**WELWYN HATFIELD BOROUGH COUNCIL
EXECUTIVE DIRECTOR - PLANNING, PUBLIC PROTECTION AND GOVERNANCE**

Application No: 6/2020/0723/LAWP
Location: 44 Vineyards Road Northaw Potters Bar EN6 4PA
Proposal: Certificate of lawfulness for the erection of an outbuilding to be used as a fitness studio and adjoining games and sitting room.
Officer: Mr Antoine Commenville

Recommendation: Refused

Plan

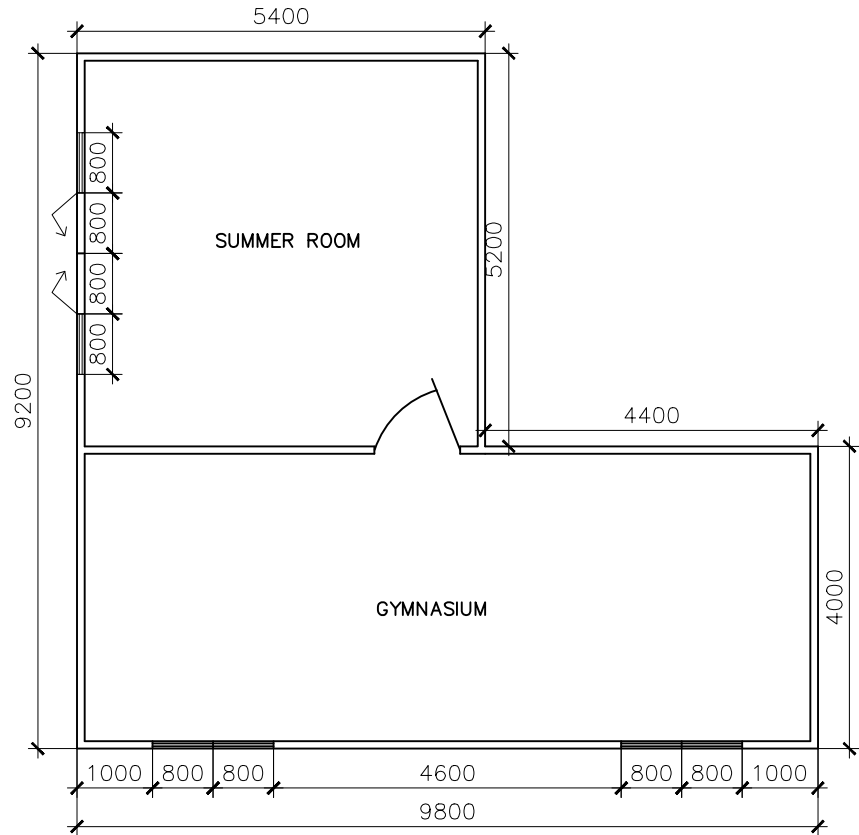
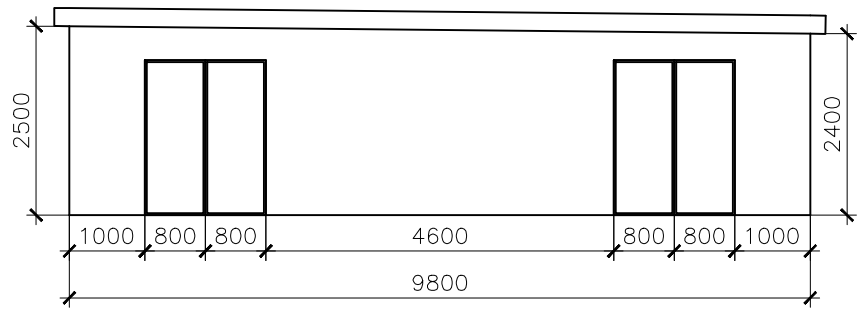
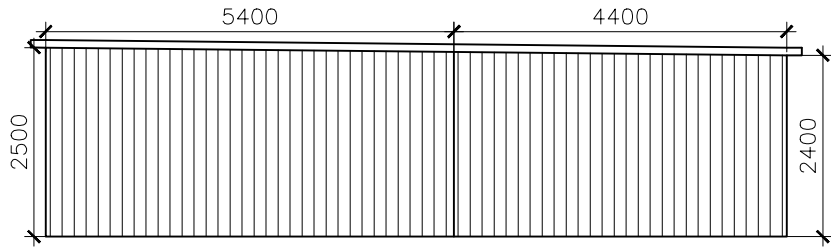
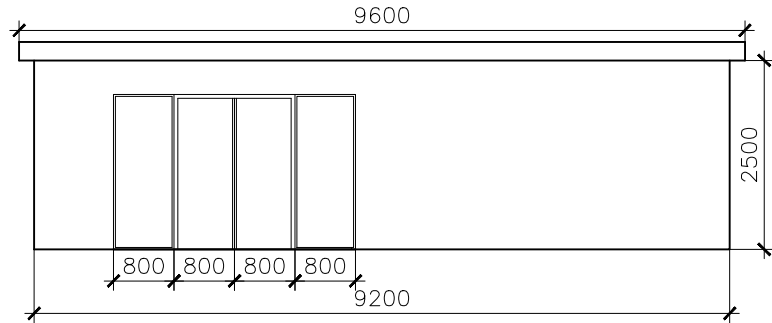
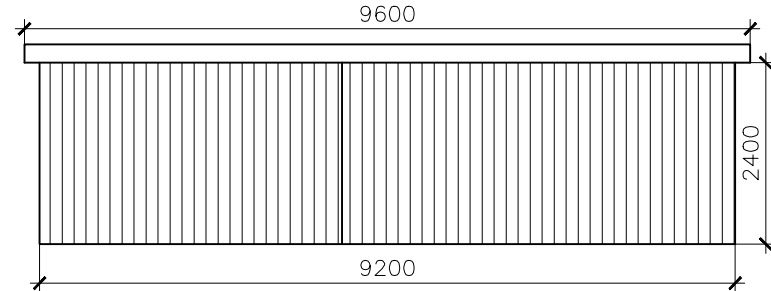
1. The outbuilding would exceed 2.5m in height and would be located within 2m of the boundary of the curtilage of the dwellinghouse. As such, the development would not comply with Schedule 2, Part 1, Class E.1 (e)(ii) of the Town and Country Planning (General Permitted Development)(England) Order 2015 (as amended). Planning permission is therefore required.
2. The height of eaves of the outbuilding would exceed 2.5m. As such the development would not comply with Schedule 2, Part 1, Class E.1 (f) of the Town and Country Planning (General Permitted Development) (England) Order 2015 as amended. Planning permission is therefore required.
